Planning Department
David Campbell, Director

June 18, 2018

**Re: McDonalds - 8315 Montgomery Blvd NE
Tract A-1-F of the Los Pastores Shopping Center
Grading and Drainage Plan - Engineer's Stamp dated: missing (F19D013A)**

C8.0

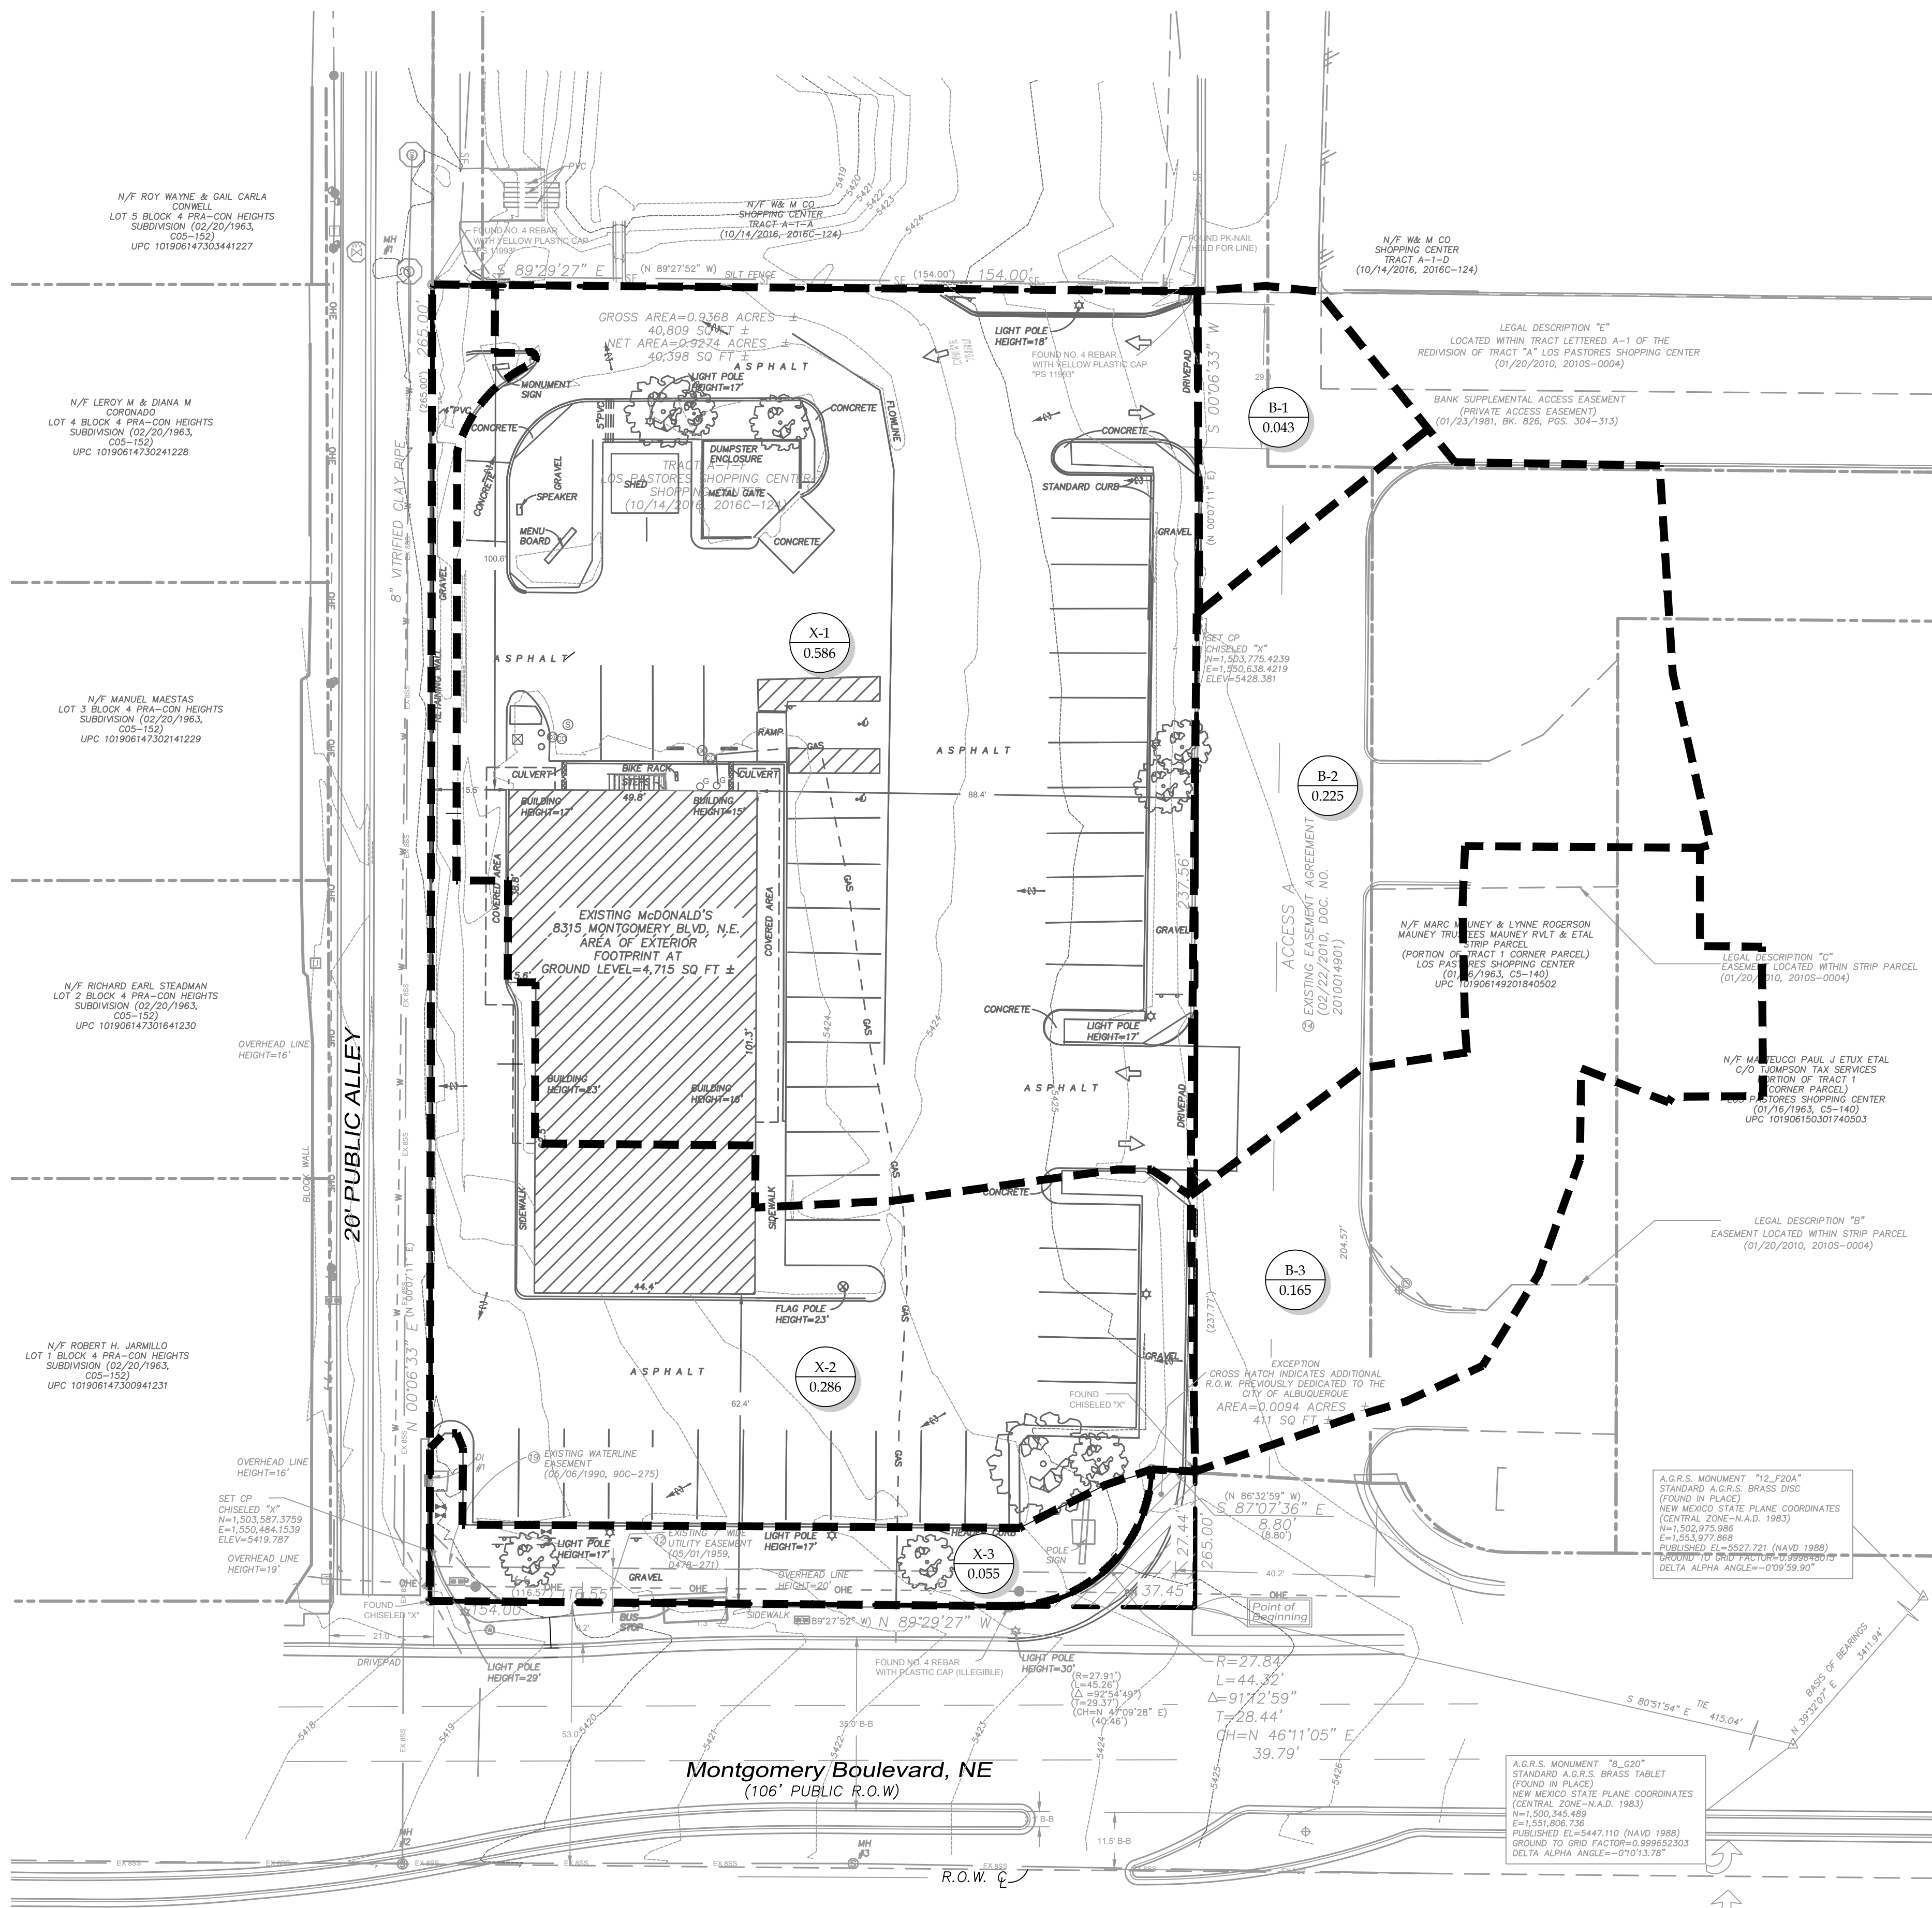
6. The proposed development plan for the McDonalds must either conform to the previously approved Drainage Management Plan for Tract A-1-F of the Los Pastores Shopping Center or a revised plan is required to determine new peak flow rates in the alley west of McDonalds and in Montgomery Blvd. using AHYMO instead of the simplified 100 year 6 hour runoff calculations in tables on sheets 8.0 and 8.2. If the proposed development plan is revised to conform to the previously approved Drainage Management Plan then the tables on sheets 8.0 and 8.2 must state the runoff rates and volumes associated with land treatments A, B, C, and D.
